CITY OF ALBUQUERQUE

December 23, 2011

**Re: Lindo Mexico Restaurant Grading and Drainage Plan
Engineer's Stamp dated 12-3-11 (K-19/D144)**

Grading & Drainage Plan

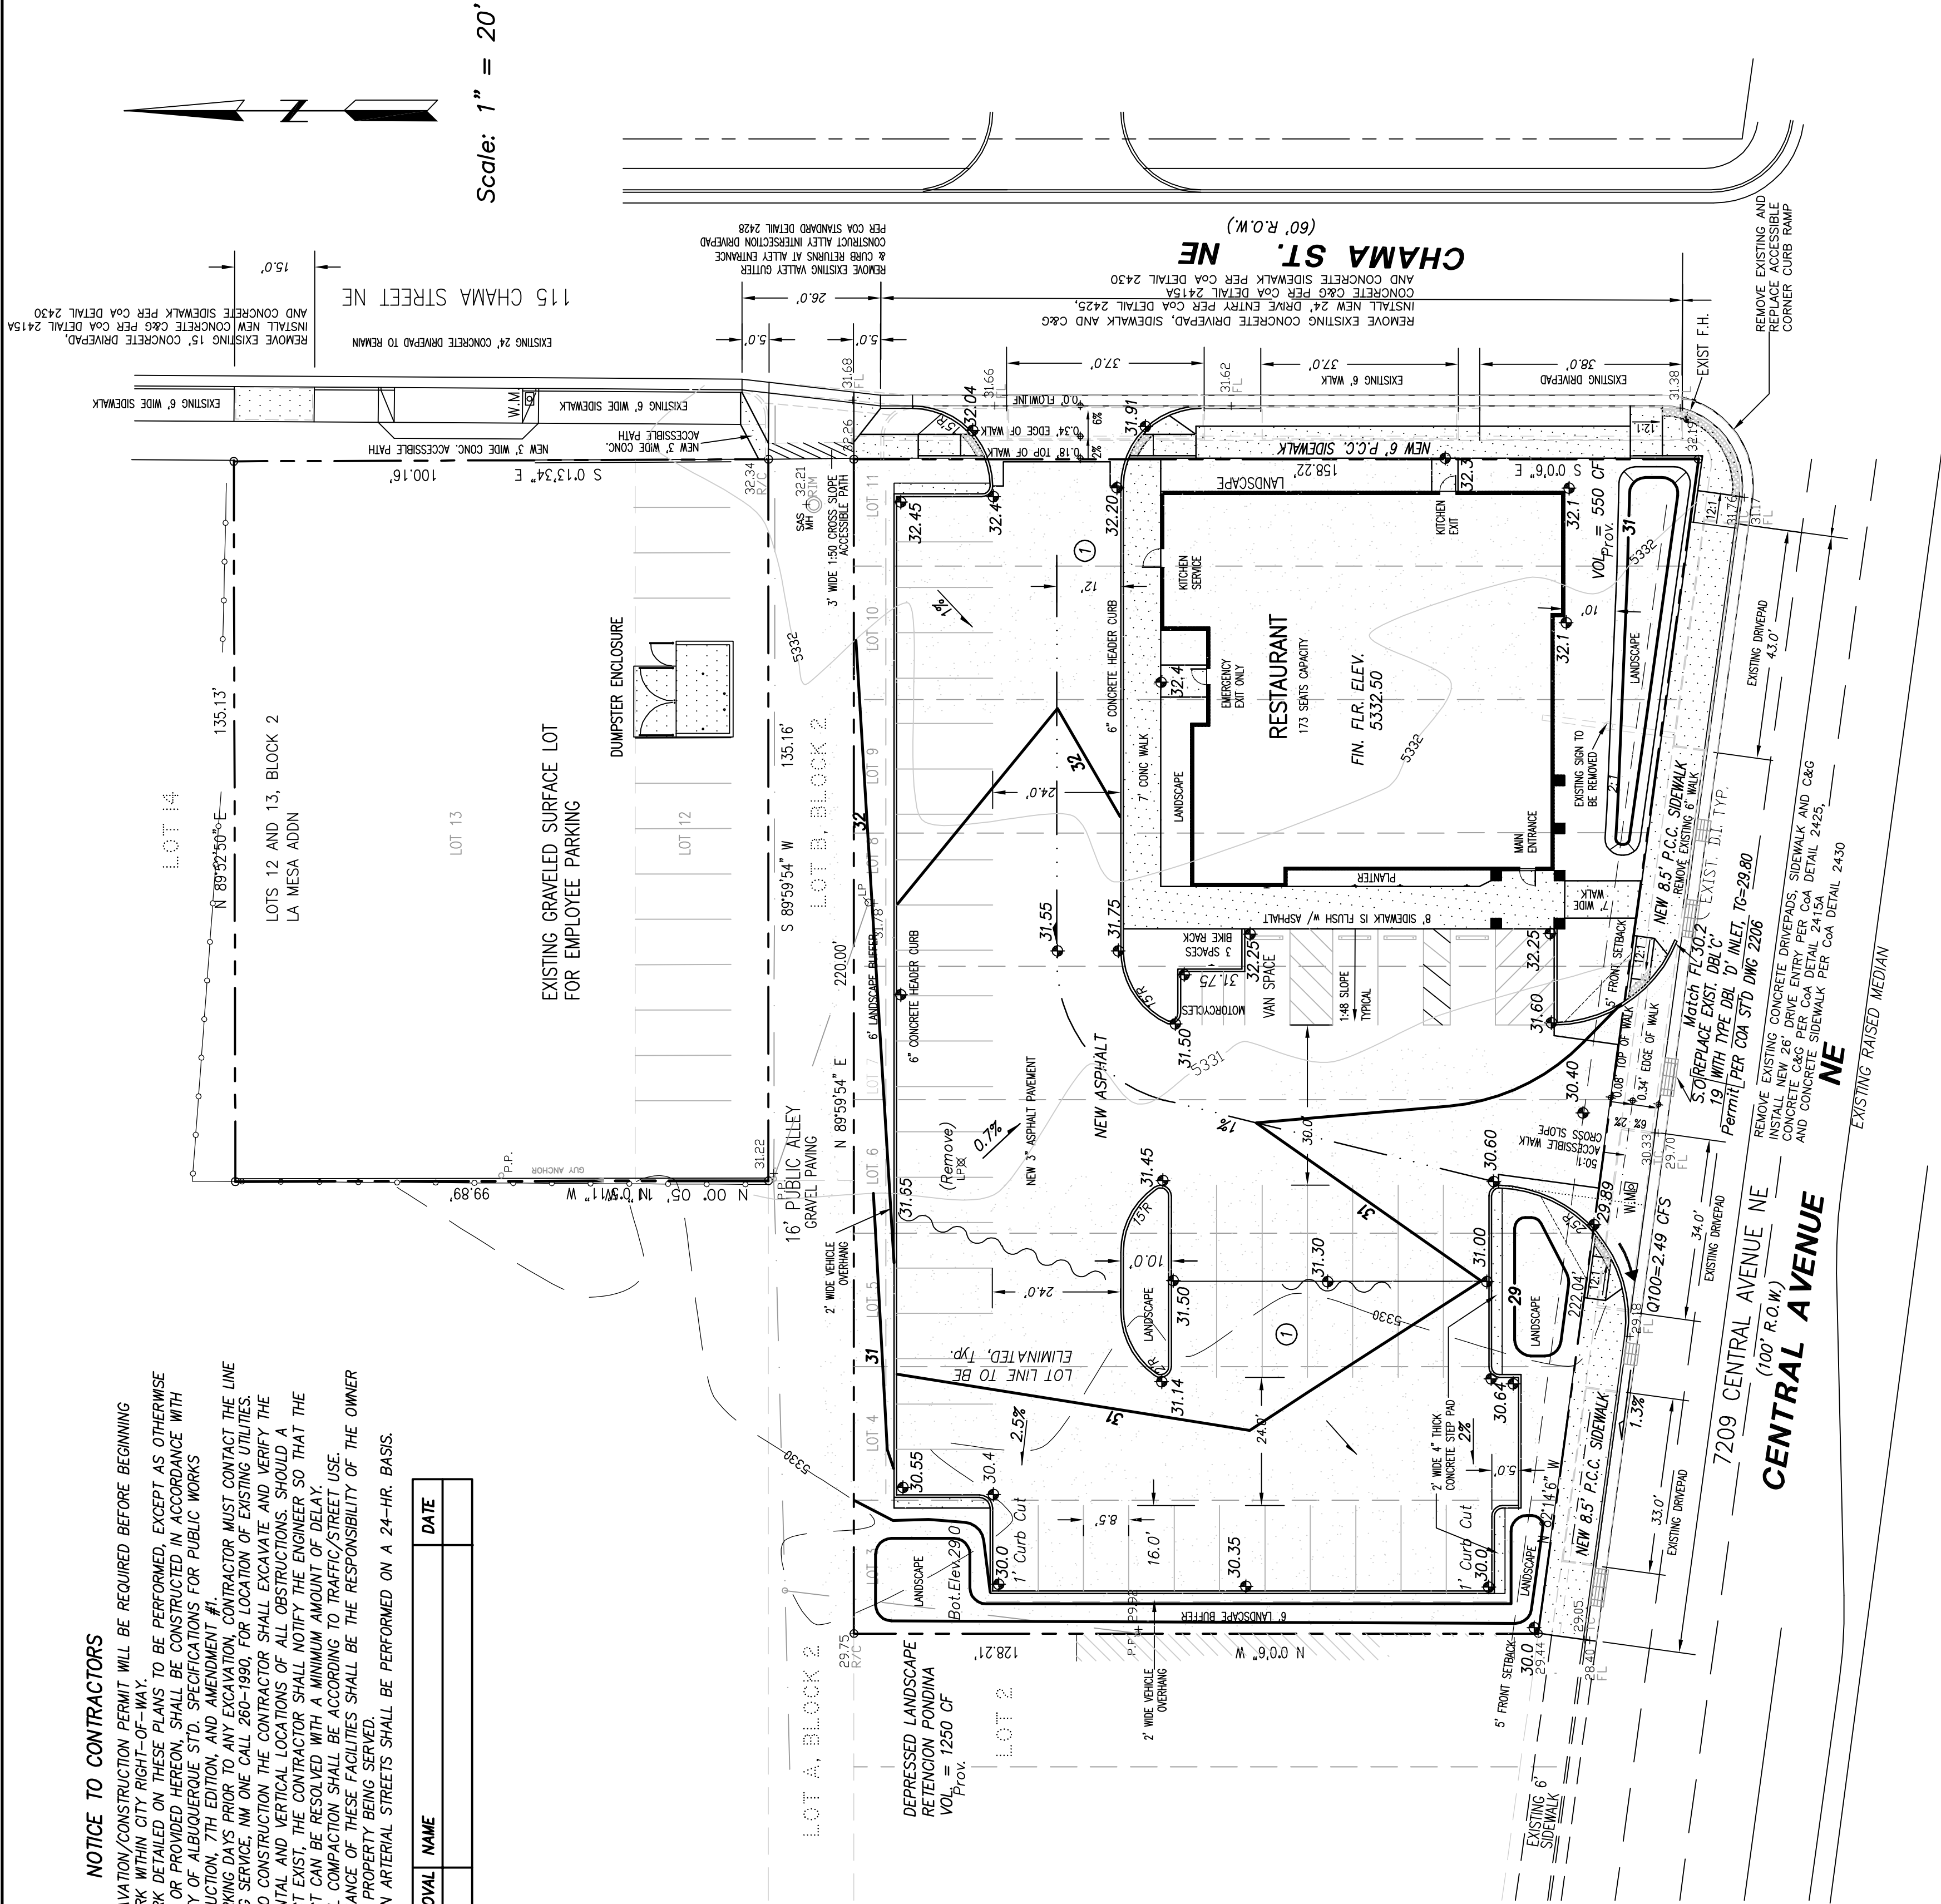
- Type C inlet will need to be placed along Central Avenue.
- Once the landscaped areas fill with water where does the water go? Discharge over the sidewalks will not be permitted.
- Please provide hydraulic calculations showing the historic flows in the area along with your developed flows.
- Roof slopes on the new restaurant need to be shown on the drainage plan.
- The actual FIRM map needs to be displayed on the plan.
- No legal description for the lot was given on the drainage plan.
